COMMENTS AND CLARIFICATIONS REGARDING CDC PLANNING APPLICATION 22/03868/OUT

I am writing on behalf of the joint owners of 2 Crouch Cottages, Bloxham Road, Banbury, by way of commentary on the above planning application with specific reference to documents submitted by the landowner's agents, elements of which appear to contain material omissions, errors and non-sequiturs. As you are aware I have been in correspondence with you and your colleagues at Oxfordshire County Council at various times regarding this application to the extent that it impinges on the quiet enjoyment of our property. It seems from our most recent exchange of emails that there has, to put it mildly, been a breakdown of communication between Oxfordshire County Council and you, the unintentional effect of which will be prejudicial to our interests if left unchallenged. I would therefore be grateful for your acknowledgement of this letter and, as requested in my email to you of yesterday, an explanation for the apparent failure to act on a request by your colleague, Roger Plater, at Oxfordshire County Council.

15.8 NEIGHBOURING DEVELOPMENTS

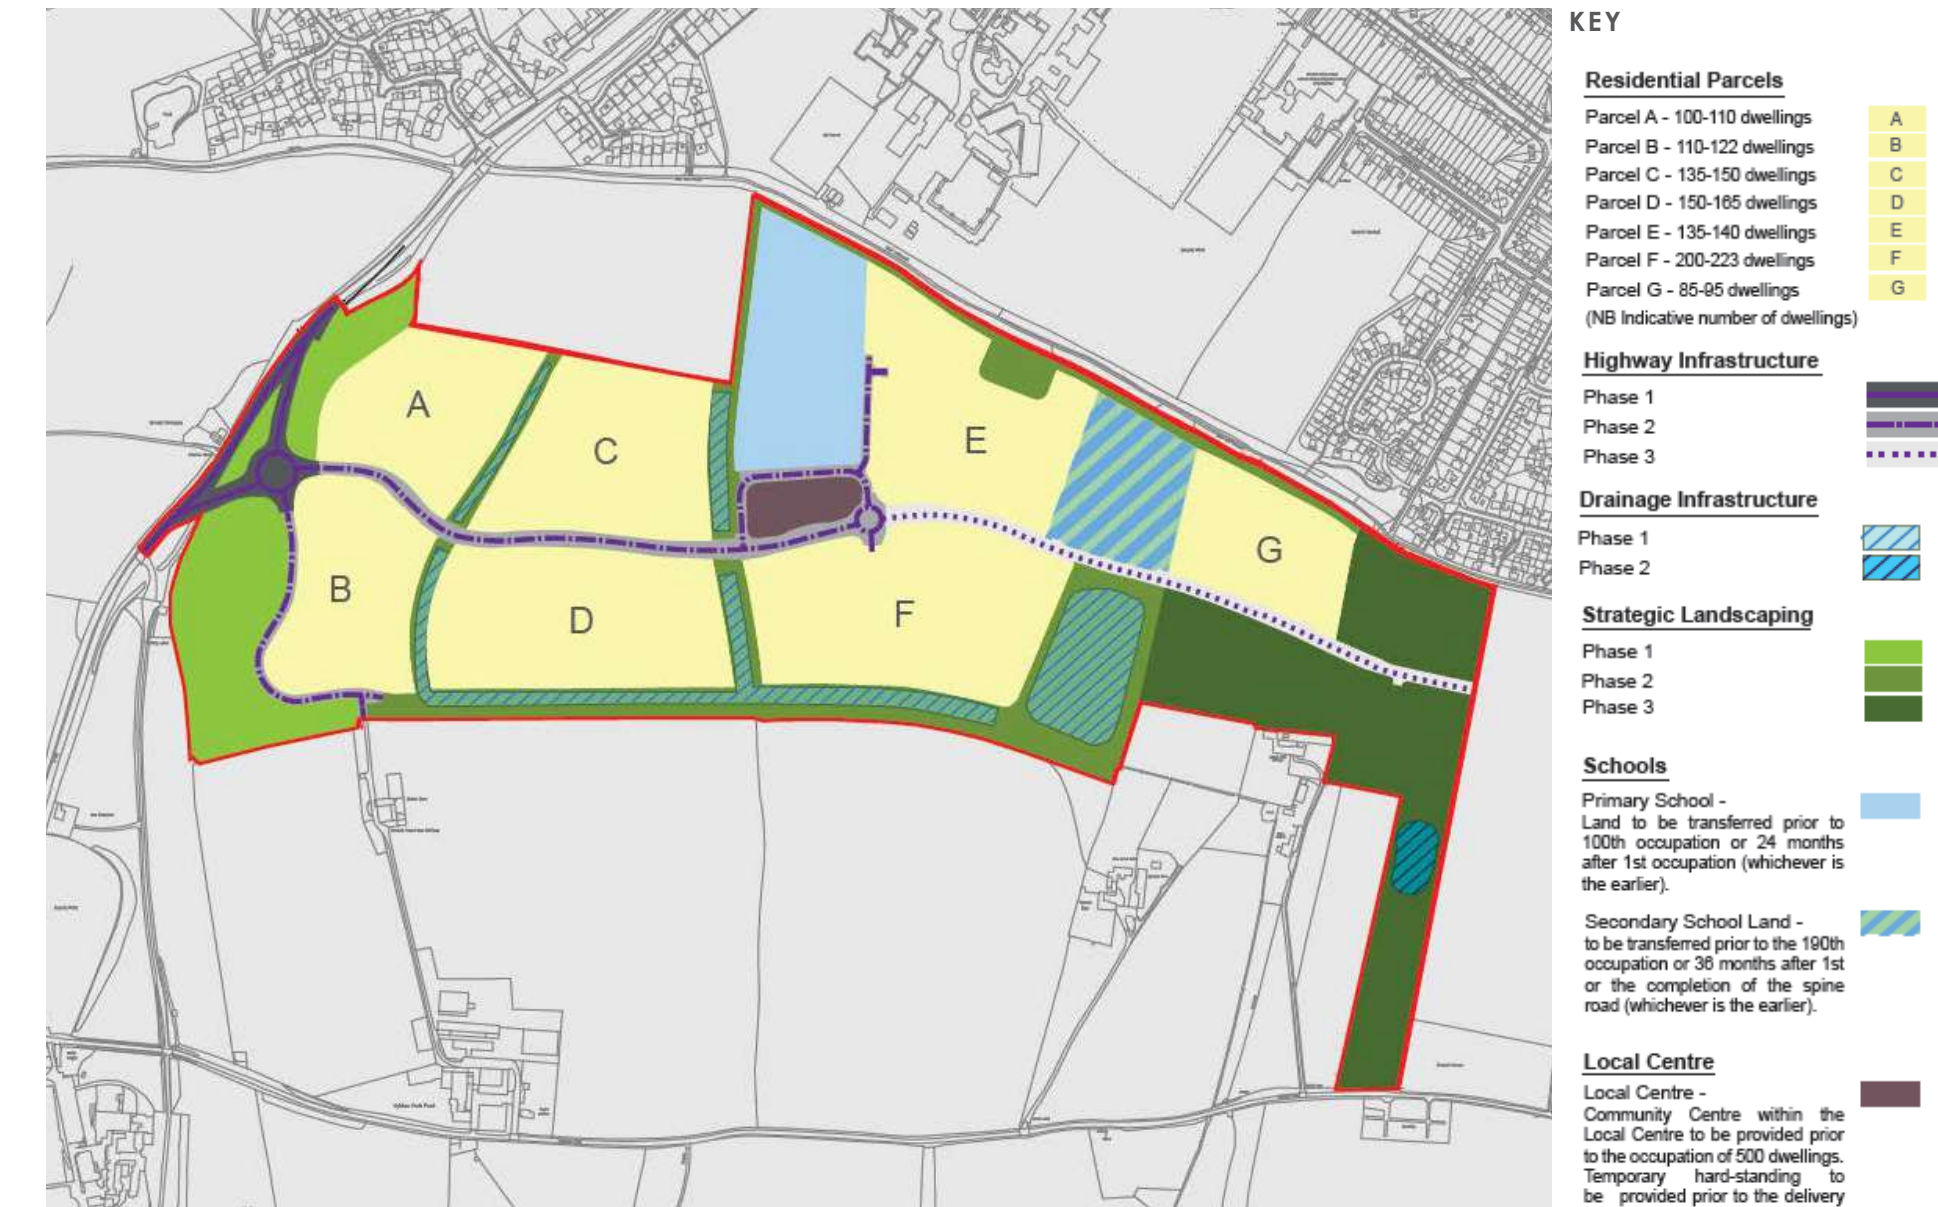
- b. The existing footpath network (referred to at several points in the document) adjacent to the cottages is shown in the plan accompanying Paragraph 15.8 and comprises footpaths 120/49/10 (as amended following the works associated with the A361 alignment), and 120/33/40 (as amended following the construction of the Redrow Estate). Paragraph 15.8.5 asserts that “there’s an extensive network of PROWs (public rights of ways) which connect the site with surrounding amenities...” and “there are key connections between surrounding approved developments to the main bridleway....”

Opportunities and Considerations Plan

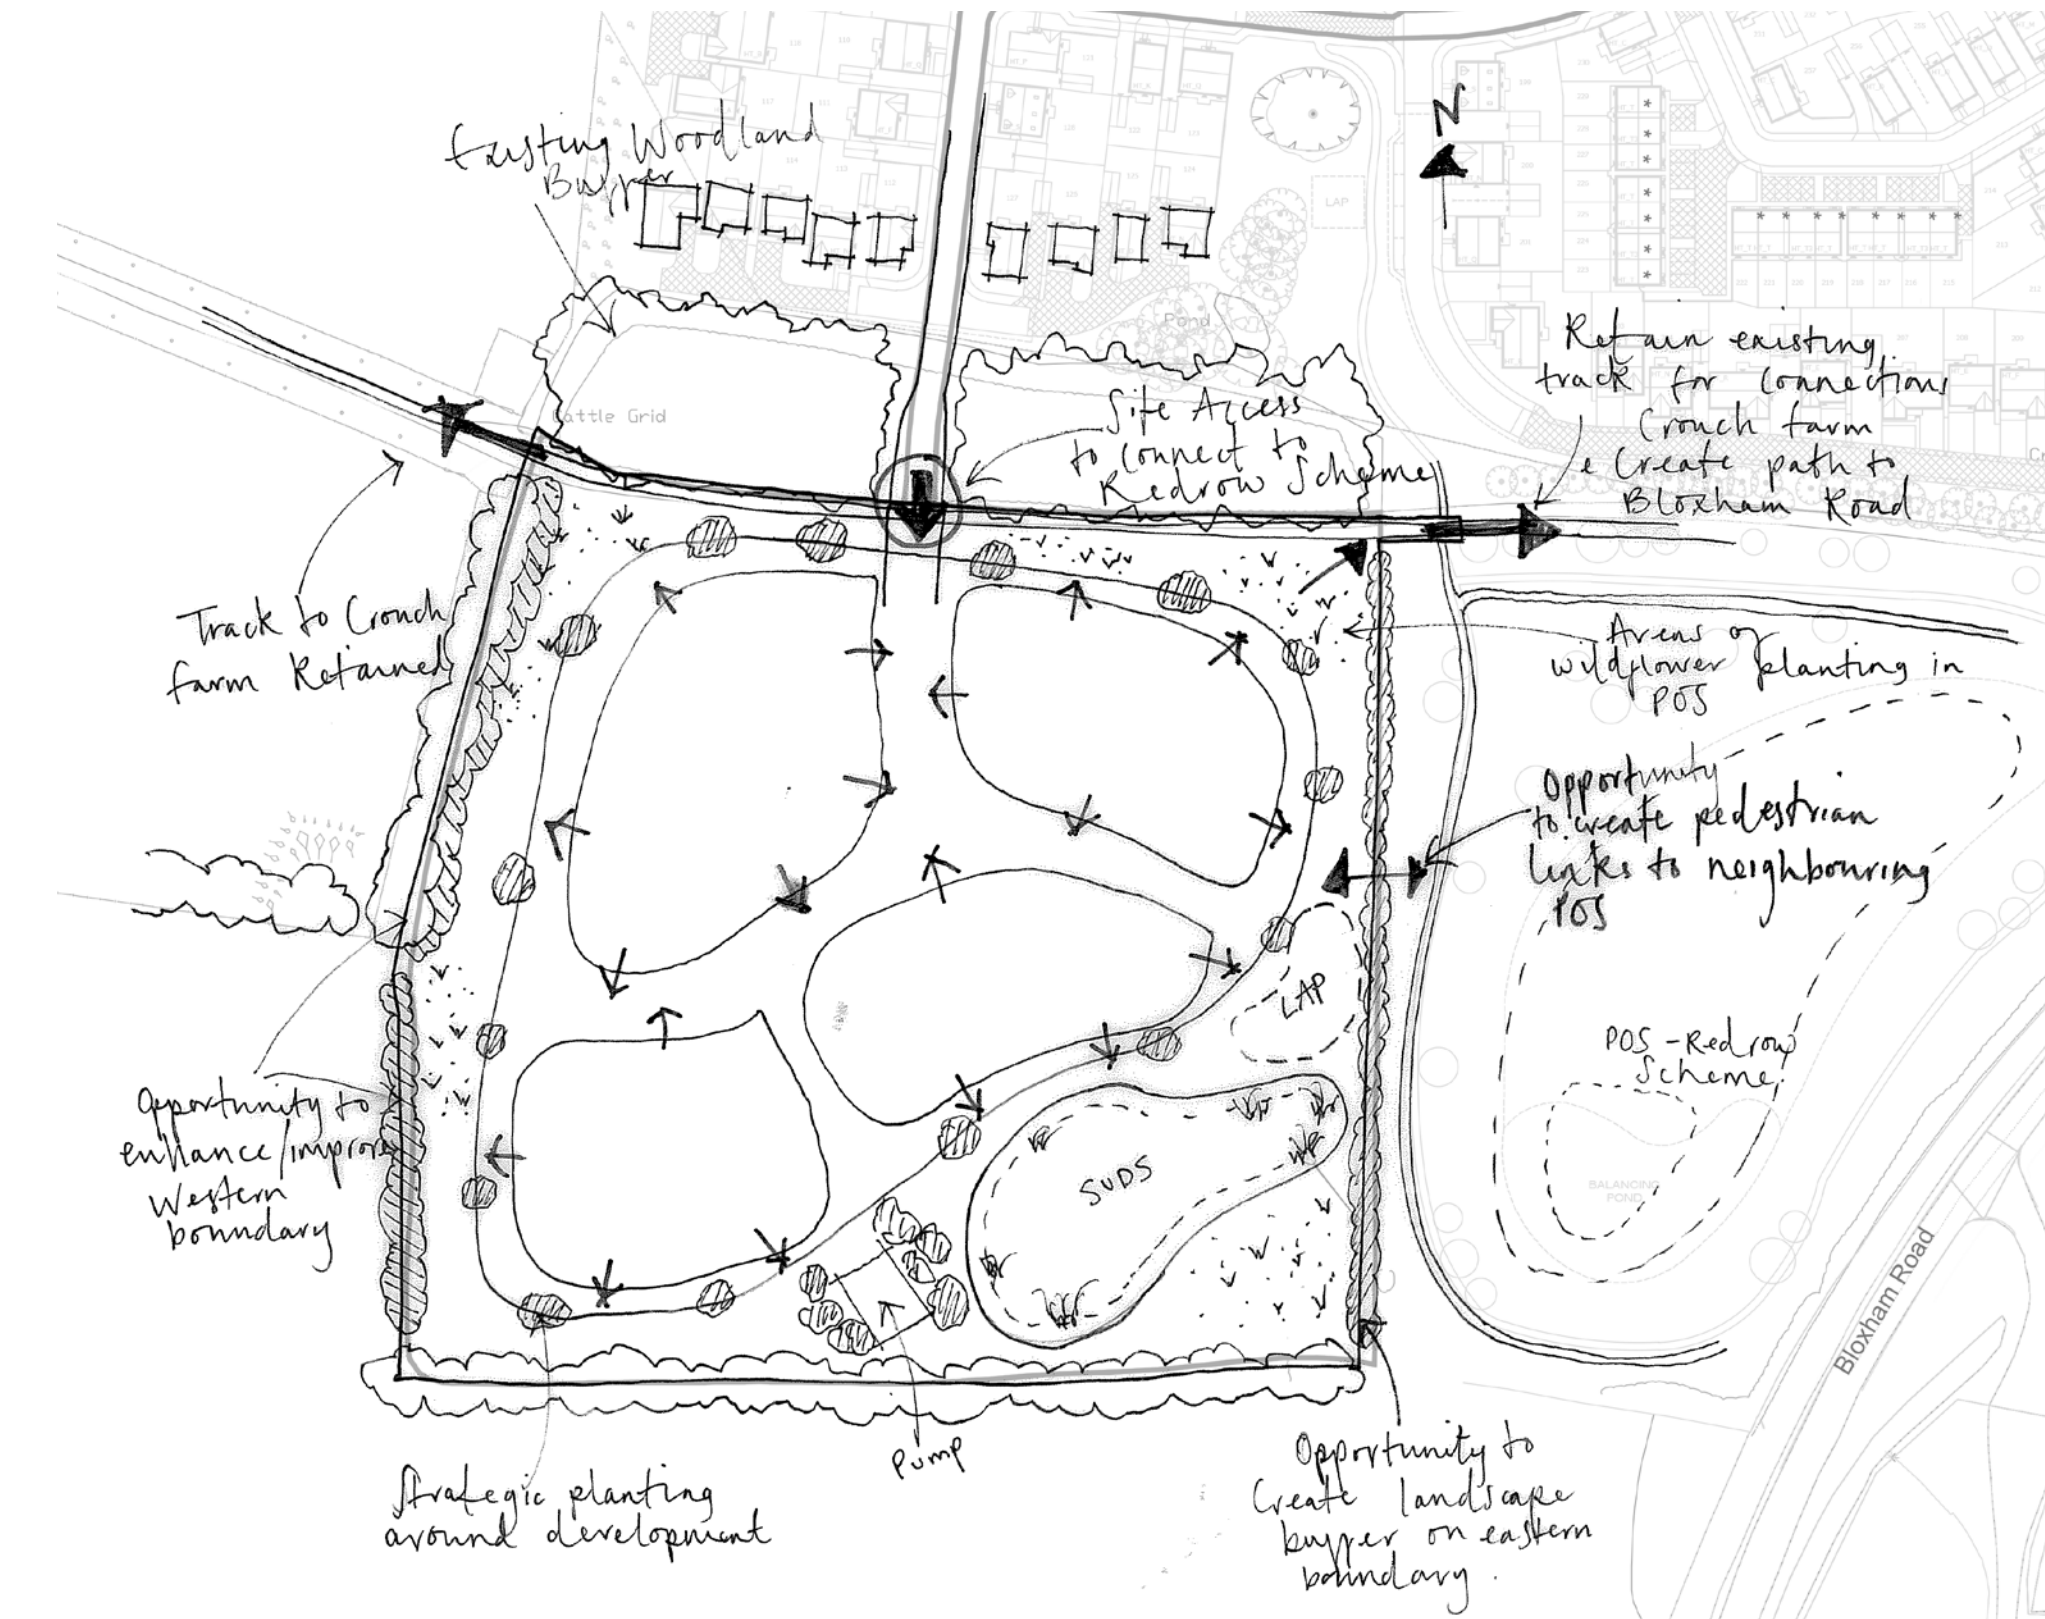
- d. It is our contention that the illustration in Paragraph 15.9 following on from the sketch in 16.1 (referred to in Paragraph a above) is therefore incorrect to the extent that the correct routing is as set out in Paragraph c above), ie the correct routing of any proposed footpath along the disused farm track must run BEHIND the curtilage of our cottages where it joins the “Redrow-approved footpath.” The footpath joins the Bloxham Road some 50 metres north east, adjacent to the bus shelter area. Put simply, there are existing public footpaths in front and behind our cottages parallel to the old A361 as set out above but there can be no footpath access through the curtilage of our property. We have unrestricted vehicular access and a footpath is entirely incompatible with vehicular traffic. This argument is further

Illustrative masterplan, proposing 65 units, submitted as part of initial proposals for application 22/03868/OUT

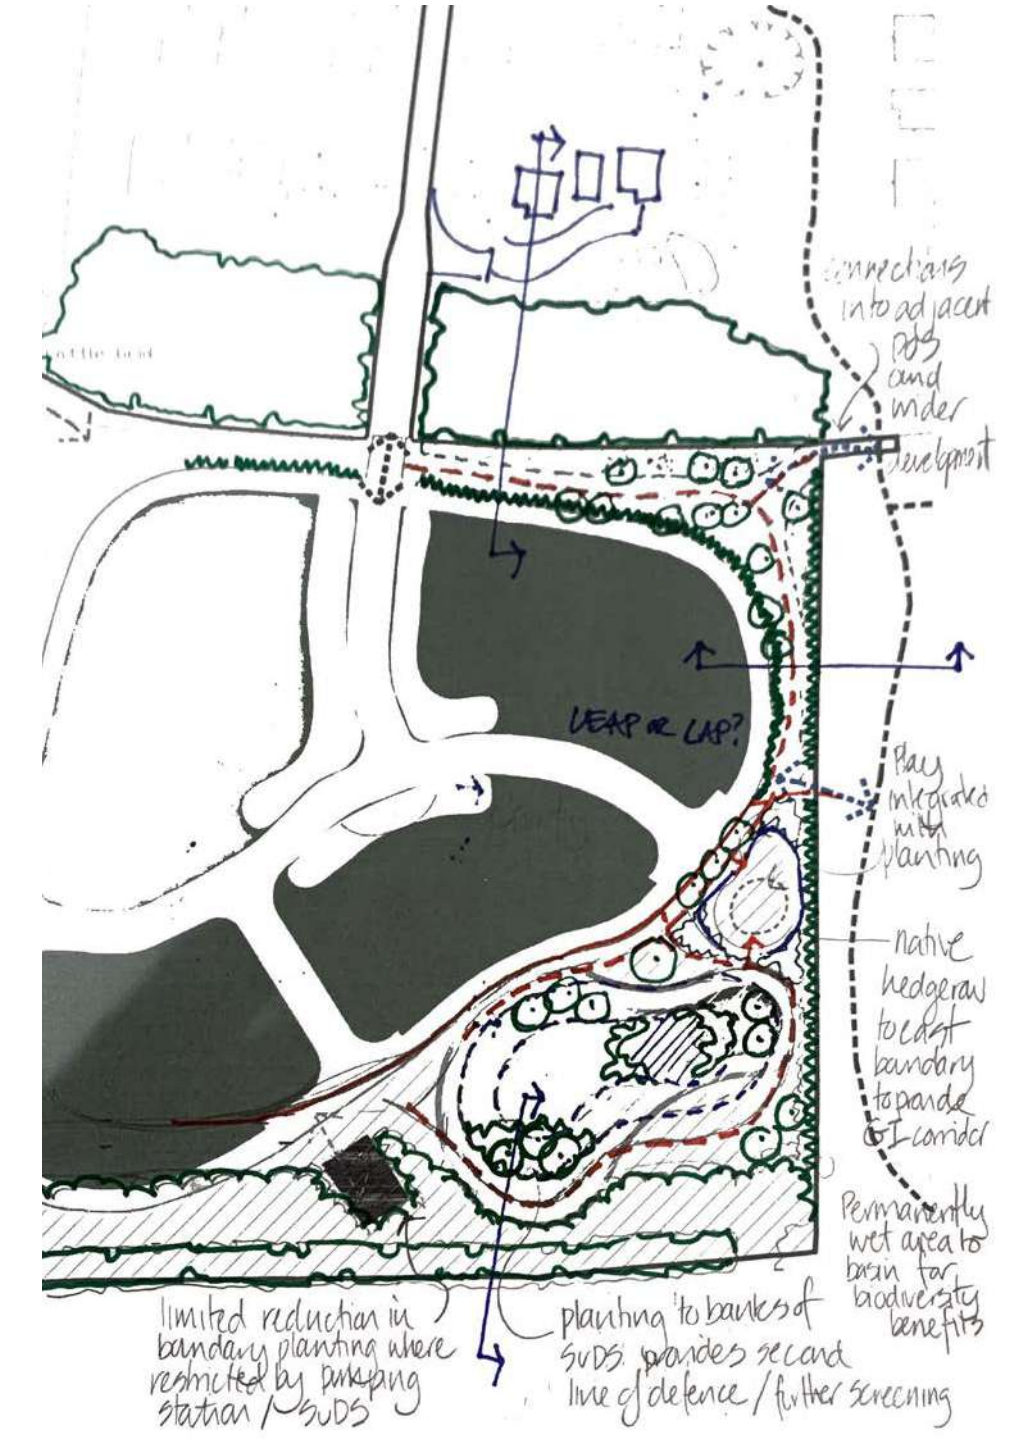
- a. Paragraph 16.1 includes a sketch map, helpfully described as being “derived from a series of internal design team reviews, alongside continued communications with the local authority” (which) “illustrate initial considerations which have taken into account key opportunities and constraints considerations” (including) “potential to reuse existing track to create new connections to Bloxham Road.” There are no references on the planning portal to these “continued communications with the local authority” to substantiate the veracity of this claim. The accompanying sketch makes reference to (sic) “Retain existing track for connections Crouch Farm create path to Bloxham Road.” This appears to manifest itself in the accompanying diagram in Paragraph 15.9 as “Proposed footpath link via disused track to Bloxham Road.” For the reasons set out below the route as proposed requires amendment.
